Application for a non-material amendment following a grant of planning permission.

Reference number:	Application Ref: CM/16/21/PL
Date of decision	22/07/2021

The installation of a new flower wall to the front elevation

Proposed Front Elevation  
Scale: 1:50

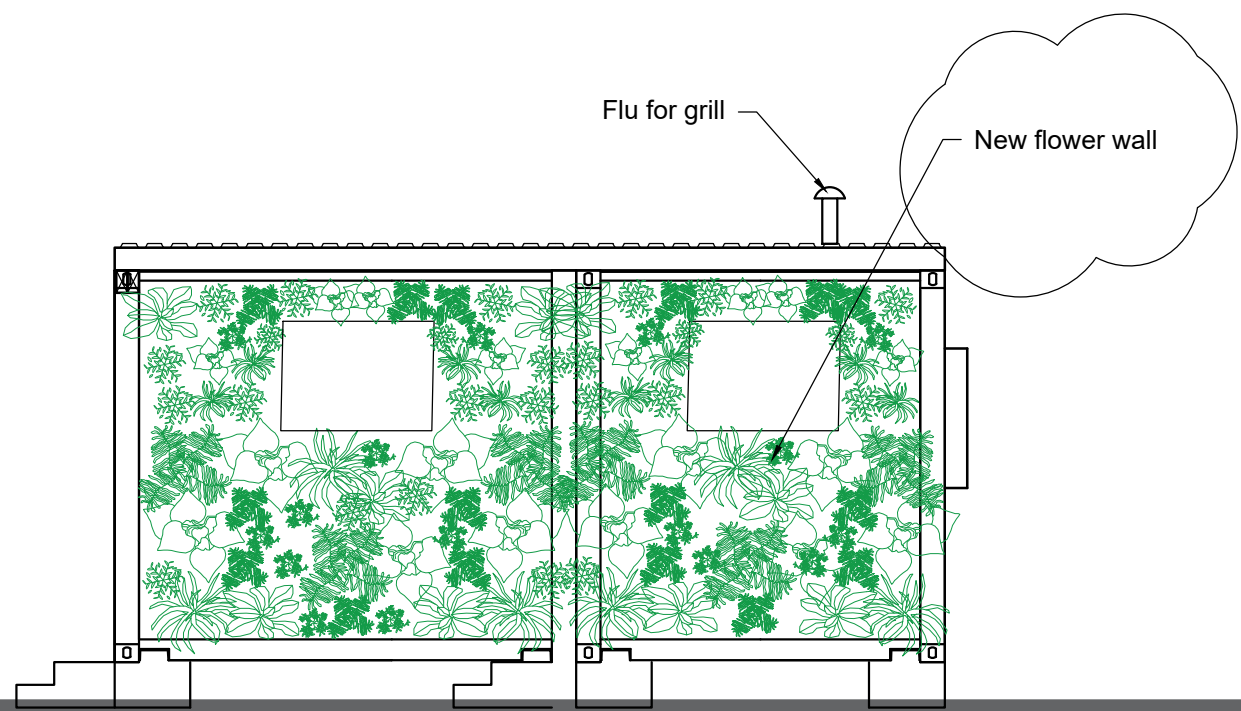
Better aesthetic to the street view. Softer appearance
